**THANET EXTENSION OFFSHORE WIND FARM (THE PROJECT)****DEADLINE 1 – 15 JANUARY 2019****NEMO LINK LIMITED****WRITTEN REPRESENTATION****RESPONSE TO EXAMINING AUTHORITY'S (EXA) FIRST ROUND OF WRITTEN QUESTIONS****1. INTRODUCTION**

- 1.1 Nemo Link Limited (**NLL**) is the company delivering the Nemo Link project (**Nemo**). Nemo is an electricity interconnector between the UK and Belgium: it will be the first electricity interconnector between these two countries, and it is a joint project between National Grid Interconnectors Limited, part of National Grid Plc and Elia Group, the Belgian electricity transmission system operator.

## Land Plan (Onshore) - Sheet 2

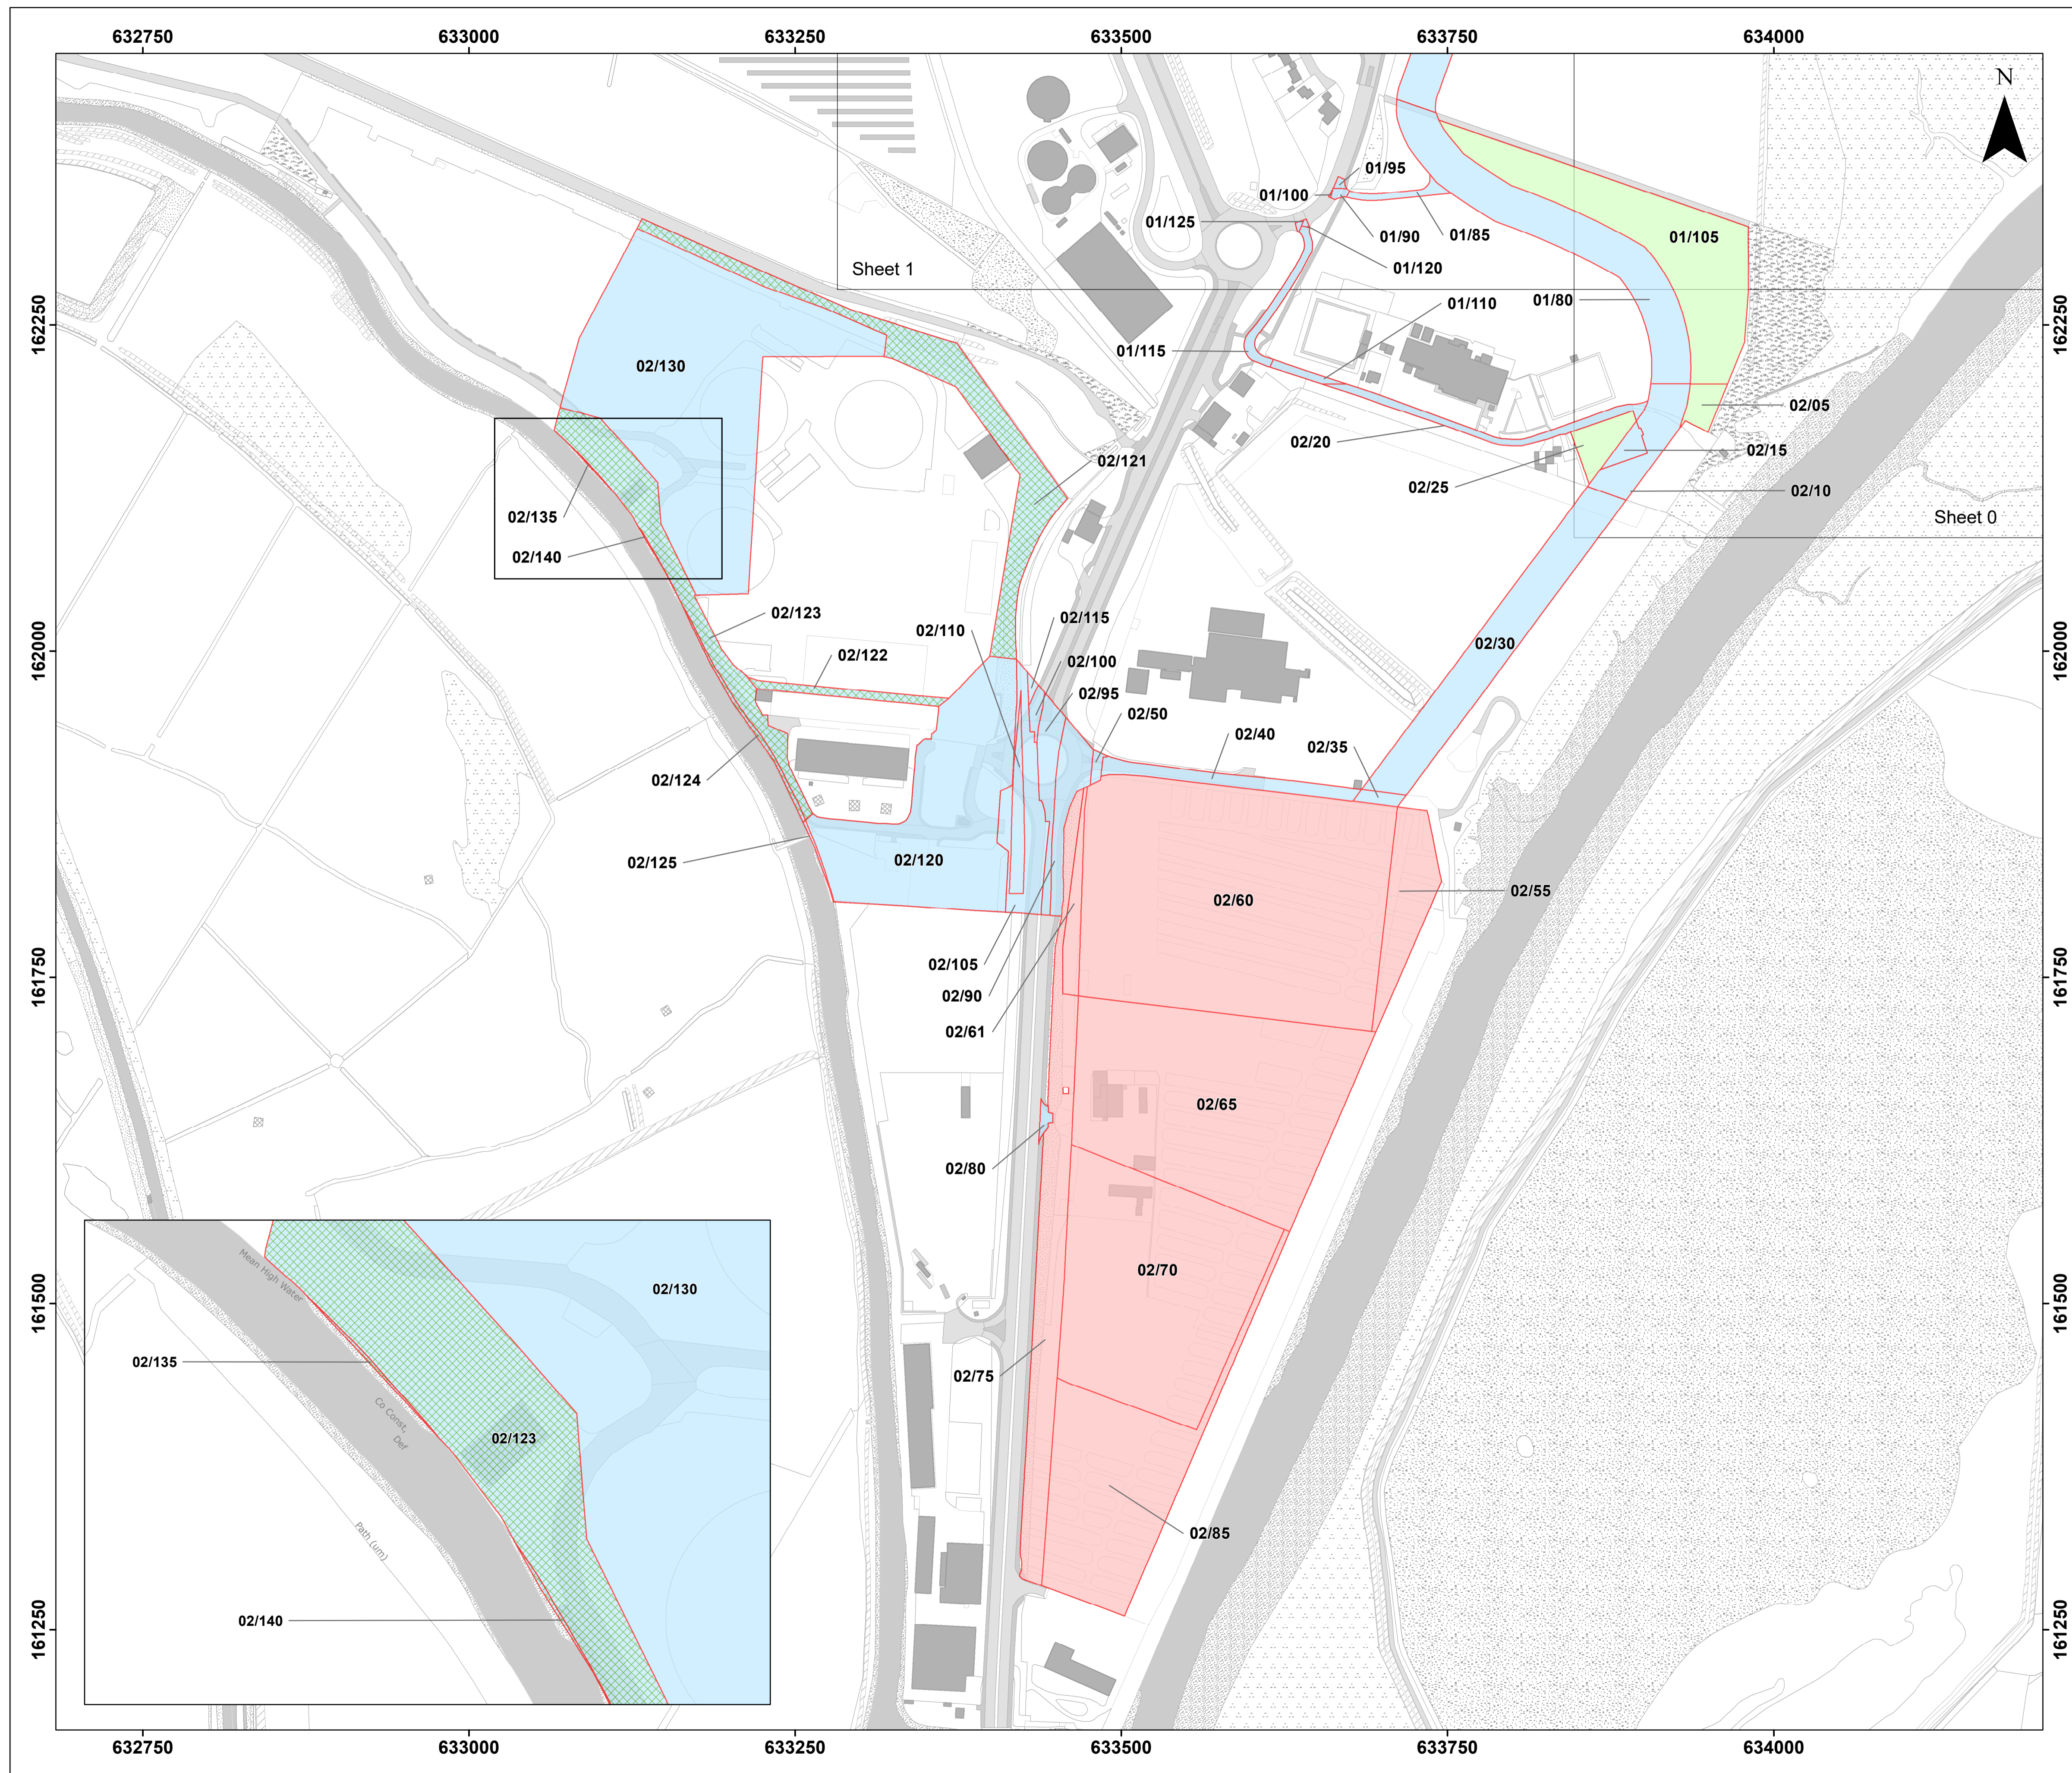
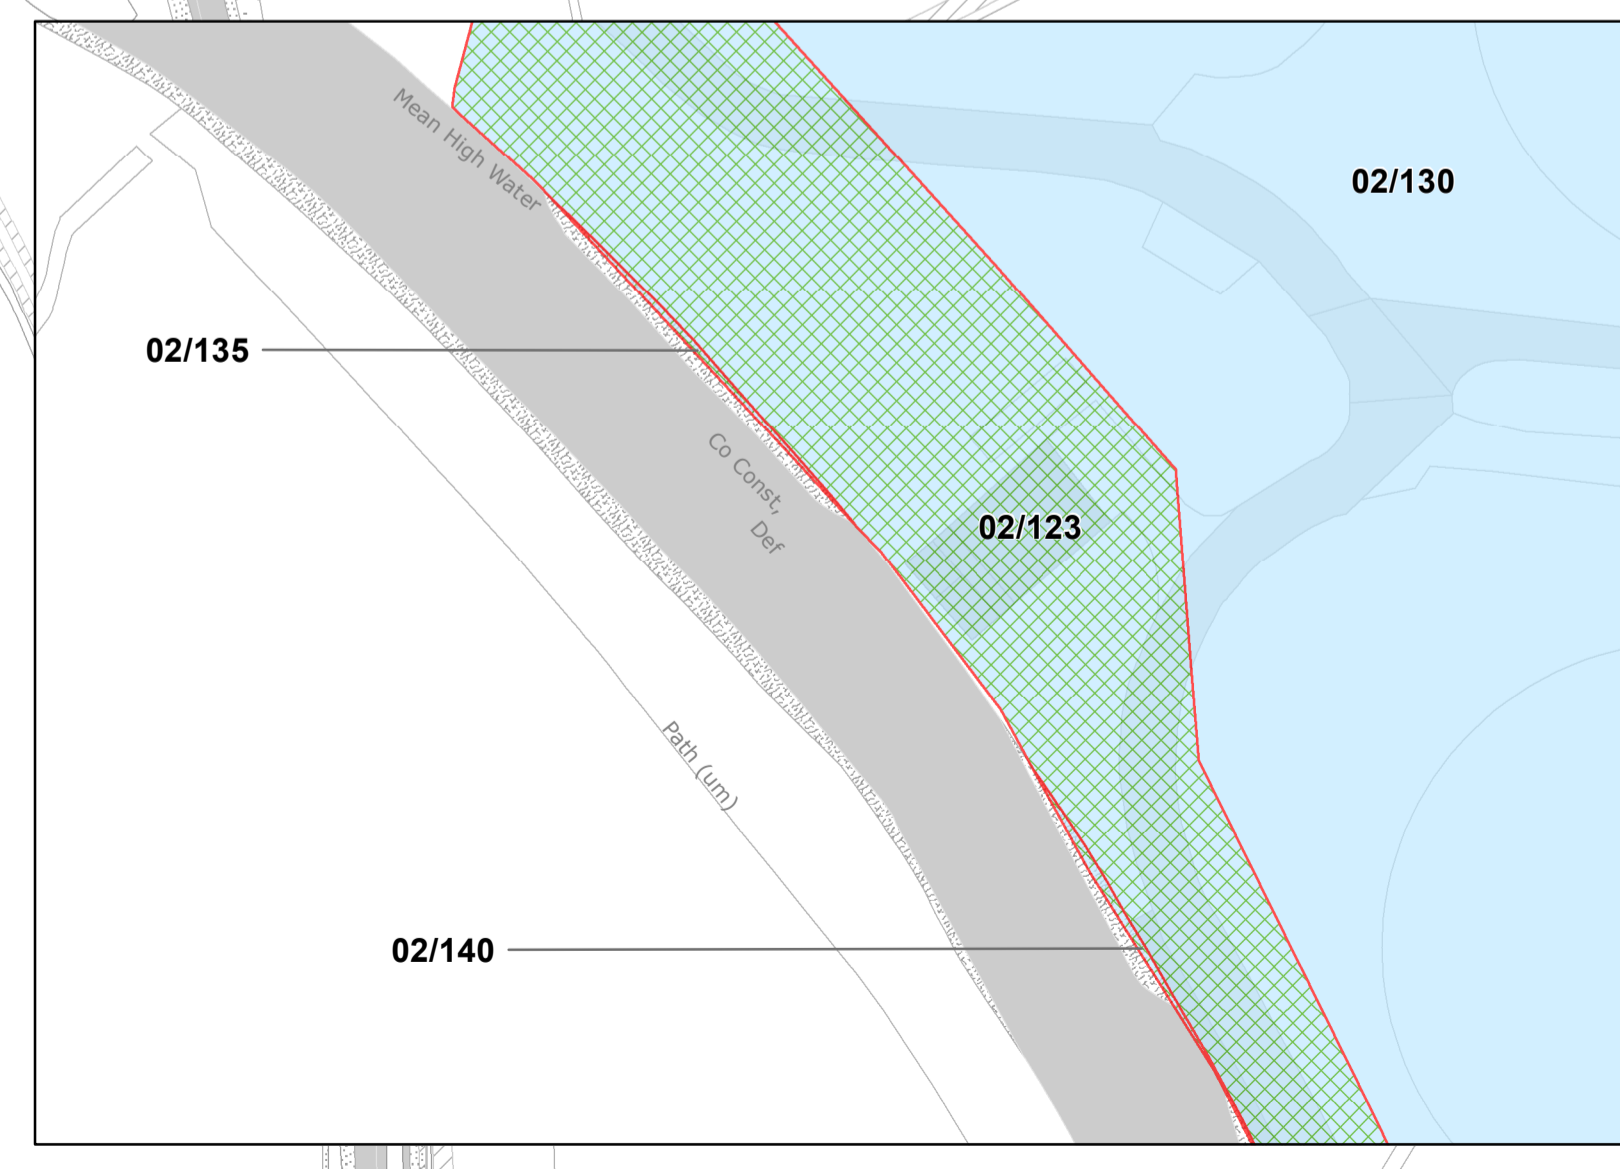
- 5.1 The Project's onshore cable route could interfere with Nemo's onshore cable at the interface with the NGET substation (the Project's Work No.16 and shown on the land plan as lot 02/121), but this appears to be just one option that the Applicant has included within its dDCO as part of Work No.16. The other options are shown as plots 02/122 and 02/124 on the land plans.

- 5.2 It is not clear from the application materials why this optionality is required, and Work No 16 is not split into options in the same way that Work No 3B is split into options. This approach is not made clear in the Works Plans or within the description of development within Work No.16 of the dDCO itself (where no optionality is identified), but it is made clear on the Land Plans where the three routes are described as options.

- 5.5 In relation to the option shown on the land plans at plot 02/121, it is not clear to NLL how this could be delivered given that this is a constrained area that includes Nemo's cables and this option would necessitate a crossing of Nemo's cables. NLL has not been provided with any information which would identify the method of this crossing. Therefore, NLL objects to the inclusion of this work.

- 5.6 In relation to the option shown on the land plans at plot 02/122, it is not clear to NLL how this could be delivered and how NLL's access could co-exist. NLL has not been provided with any information

5.7 Given that the Applicant has included three options in respect of Work No.16, and only the options to the north/north east and the south of the existing substation would interfere with Nemo, NLL's position is that Work No.16 should be amended so as to:

5.7.1 remove the cable route to the north/north east of the substation (which is excluded from the order limits and is shown on the land plans and work plans as the larger of the two "islands" in between Work No.16) as part of Work No.16 (shown as plot 02/121 on the land plan);

5.7.2 remove the cable route to the south of the substation as part of Work No.16 (shown as plot 02/122 on the land plan); and

5.7.3 only include the cable route to the west/south west of the substation as part of Work No.16 (shown as plot 02/124 on the land plan).

Access Plan -
Sheet 2 of 2

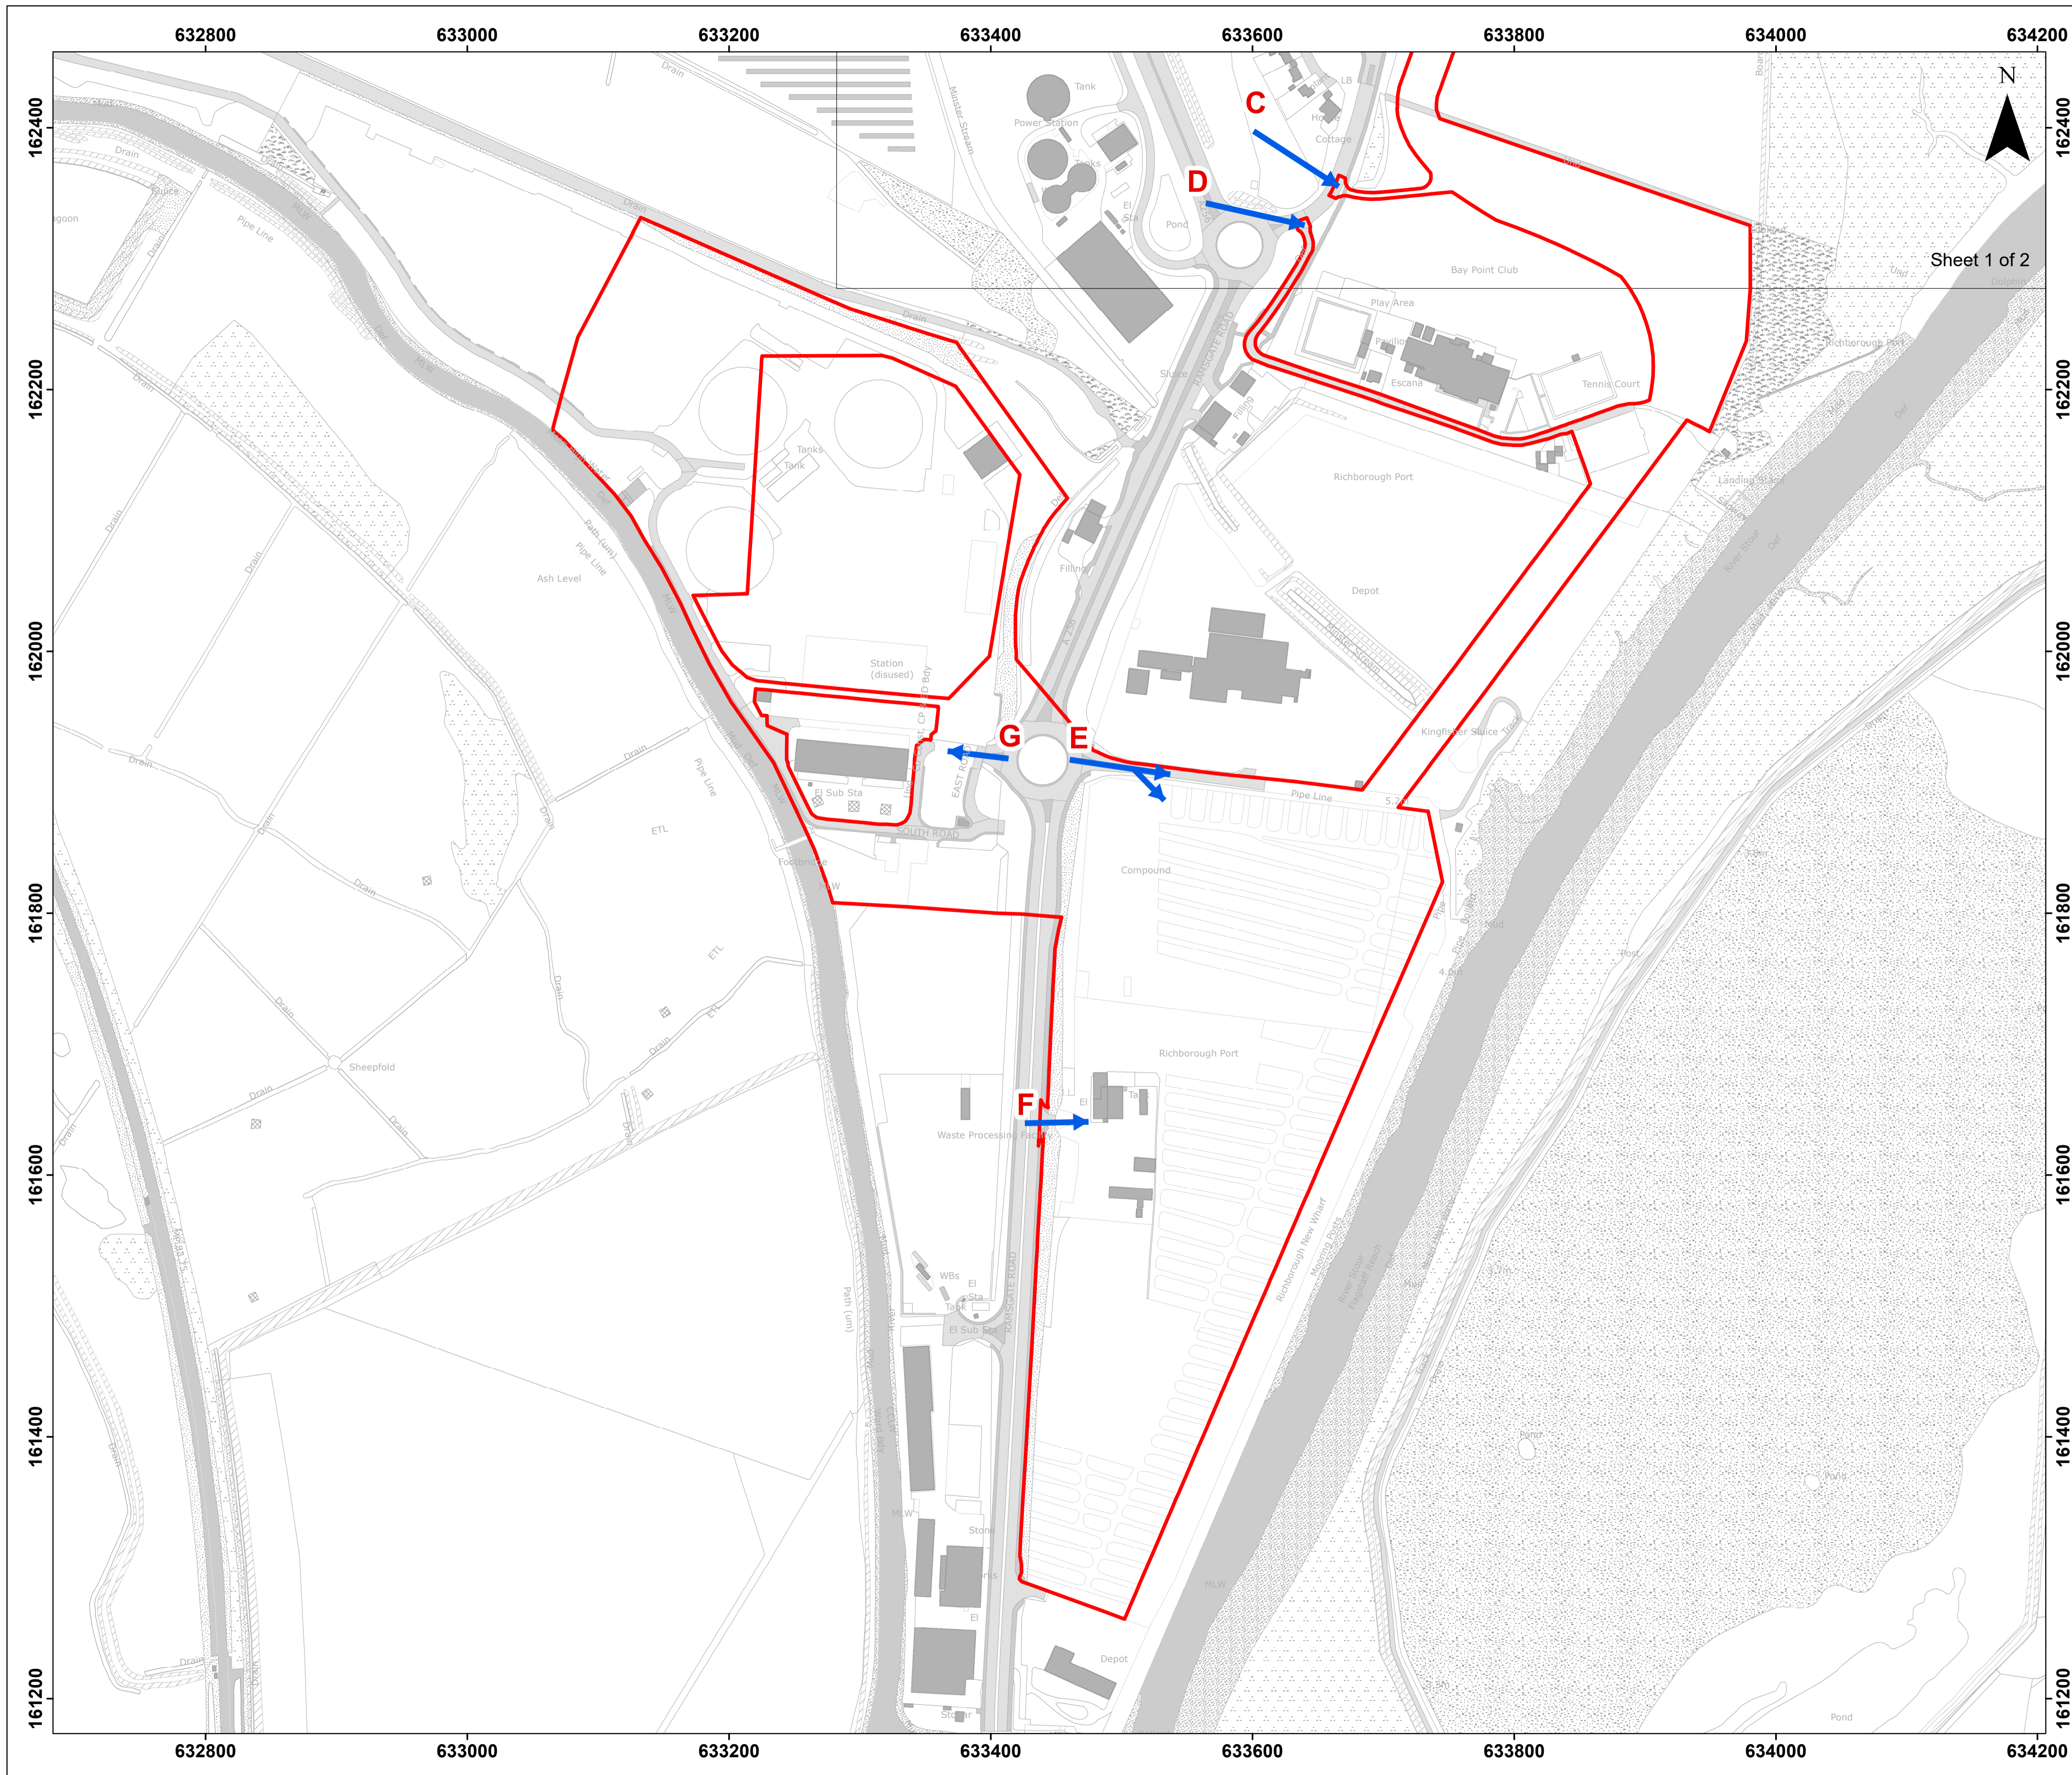
- 7.1 The Project seeks the upgrading and widening of an existing access from Sandwich Road and more importantly the crossing of the surface laid Nemo cables by vehicles to access Work No 4A, 4, 3B. The surface laid Nemo cables were not constructed with the intention of heavy construction traffic crossing them. No details have been provided to demonstrate how the construction traffic will cross the existing chalk bund where Nemo's cables are surface laid. Therefore, NLL objects to the inclusion of this work.

- 7.2 NLL has not been provided with technical details as to how this access track would be constructed, or sufficient details to demonstrate that it would not adversely interfere with the Nemo cable.

- 7.3 NLL's preferred technical solution would be one that completely avoids the surface laid Nemo cables, for example by the delivery of a bridged solution that does not involve the crossing of the surface laid Nemo cables by construction traffic.
